**From:** Brian Banister [redacted]  
**Sent:** 23 January 2022 16:30  
**To:** Planning.Responses <Planning.Responses@arun.gov.uk>  
**Subject:** Re: Planning Consultation on: BR/294/21/PL

Thankyou for the consultation. The comments of the **Arun District Conservation Area Advisory Panel** are as follows:

**Application No:** BR/294/21/PL

**Site Address:** 2-10 The Hatters Inn Queensway Bognor Regis PO21 1QT

Drawing Title:
PROPOSED EAST & WEST ELEVATION

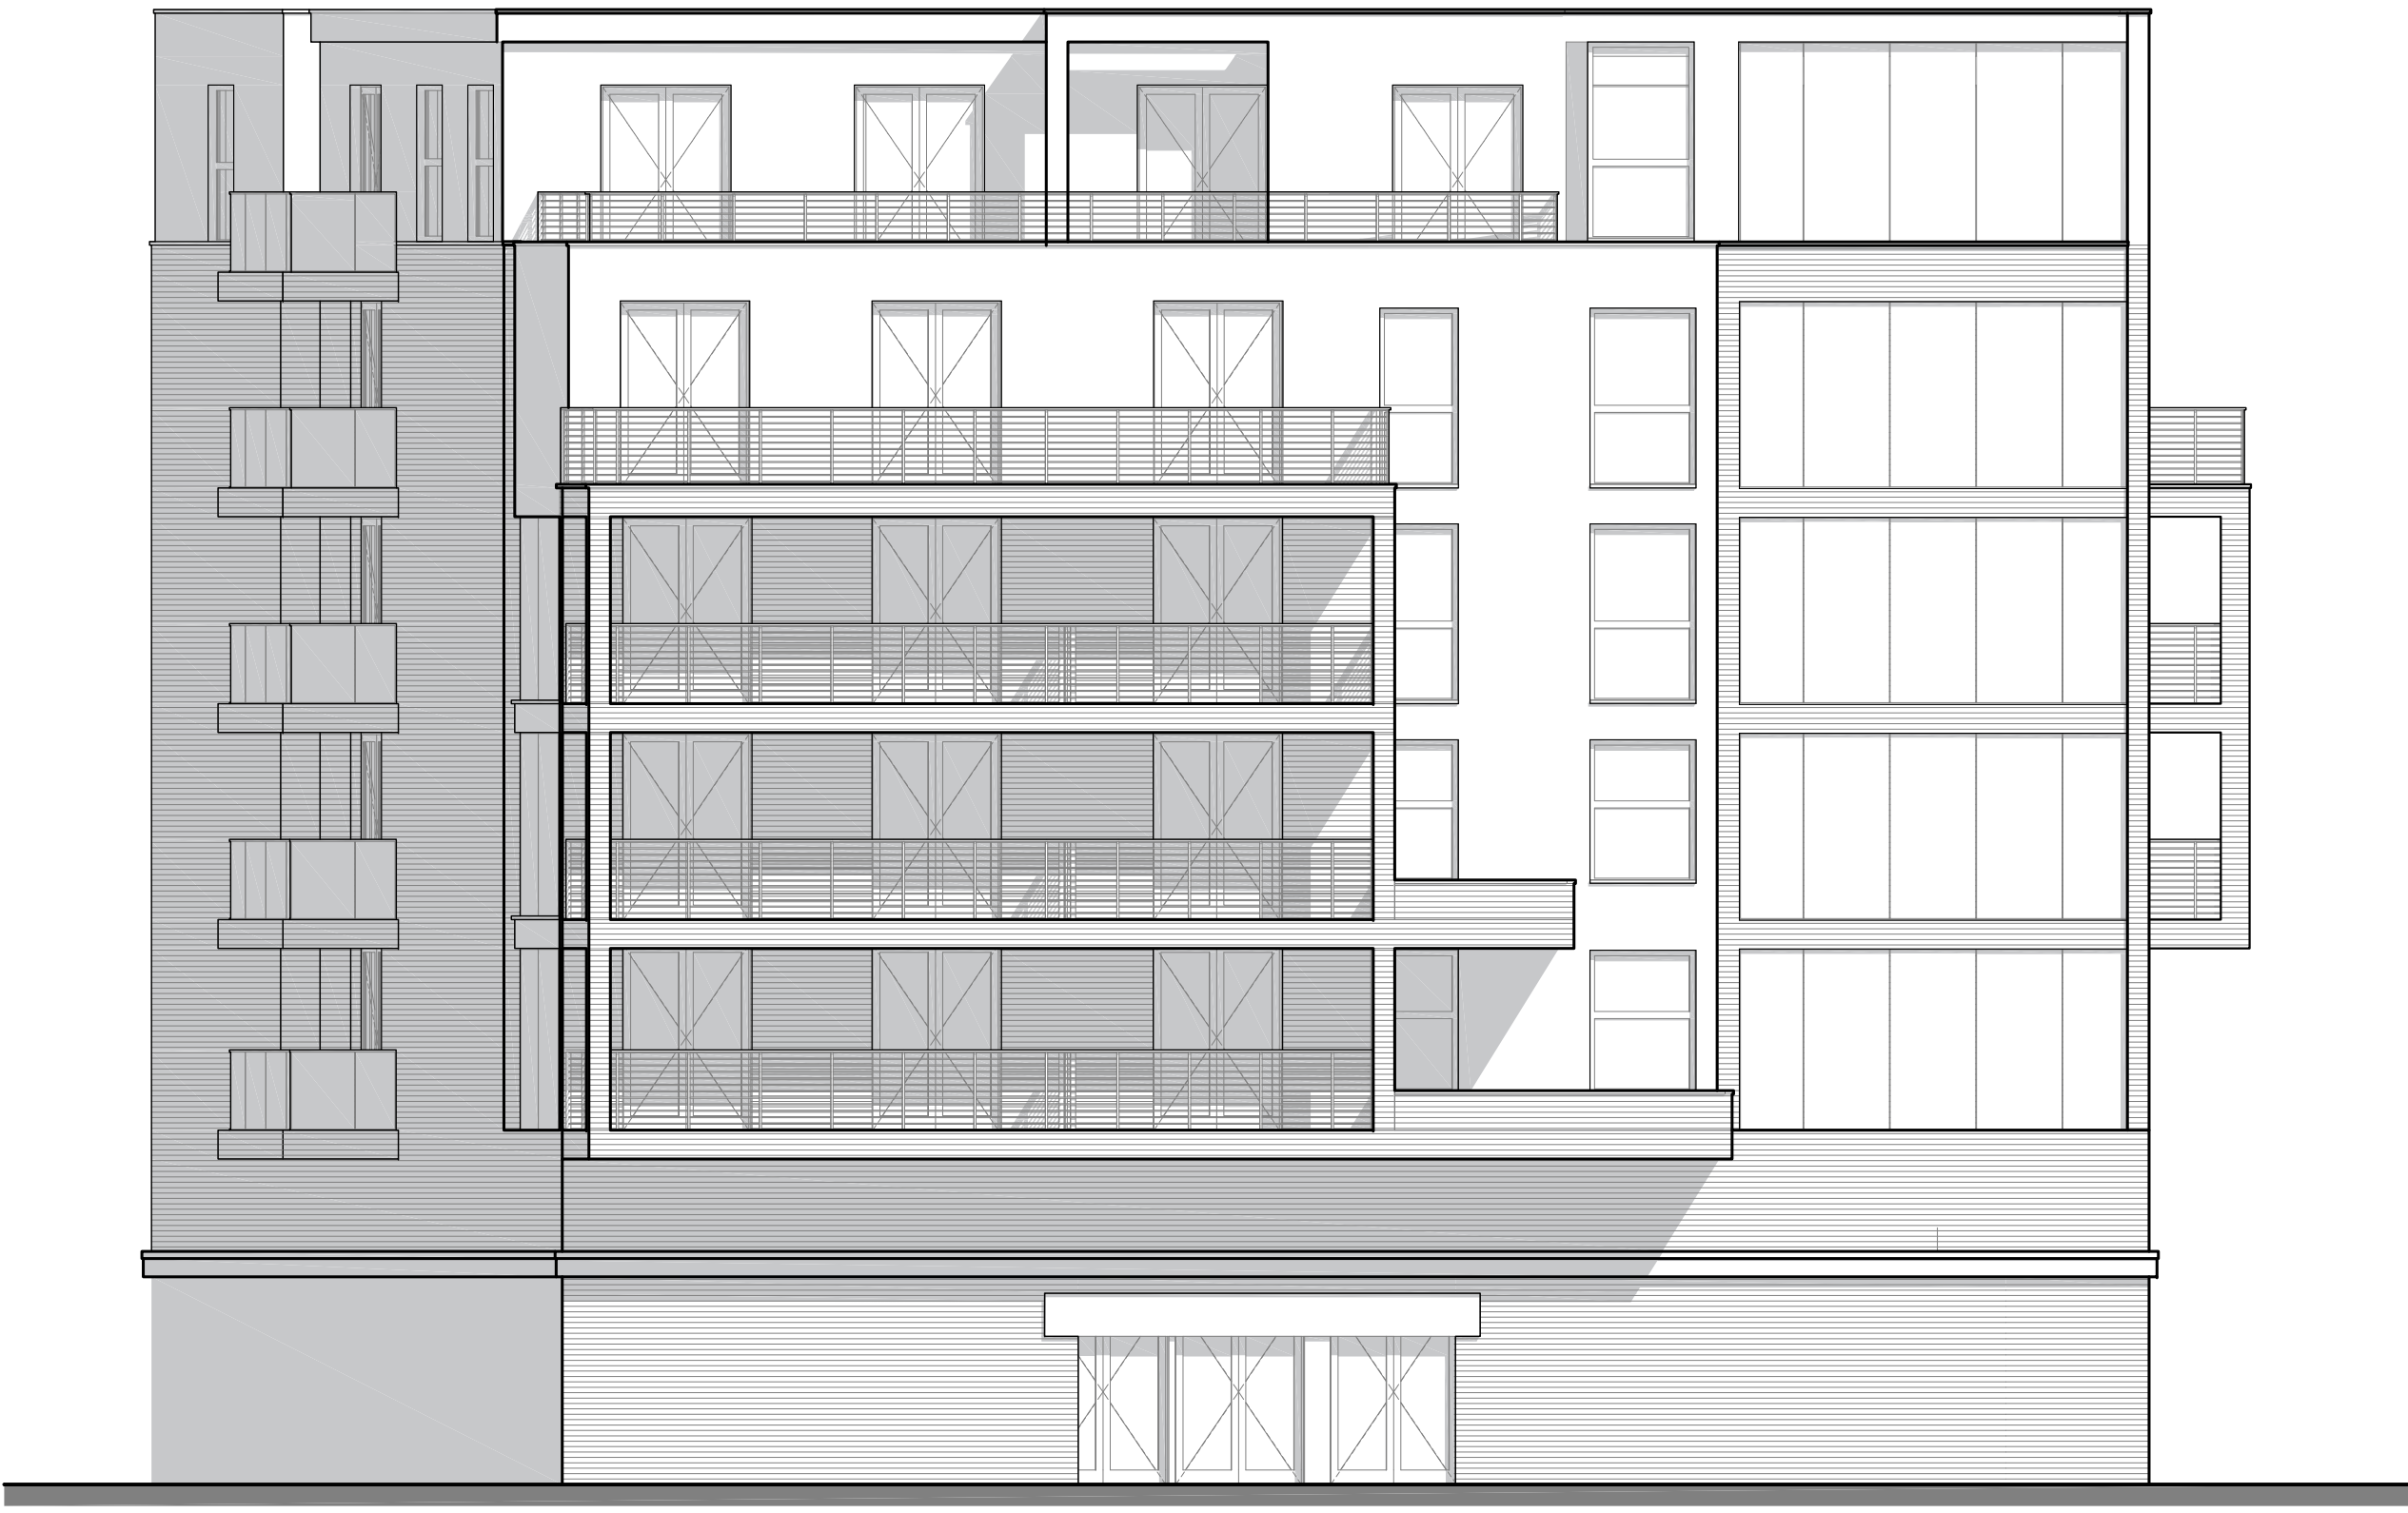
There is a substantial increase in height over the existing building on the site but there are no drawings or other graphic information showing the exact height relationship with adjoining and nearby buildings and, importantly, the relationship with the Bognor Regis Methodist Church directly opposite. From the information which is available it is most likely that the scheme will visually detract from the setting and prominence of this church building which is

As seen from West Street the proposed building will appear particularly bulky and somewhat lacking in architectural interest to the further detriment of the setting of the Methodist Church and, therefore, also that of the conservation area.
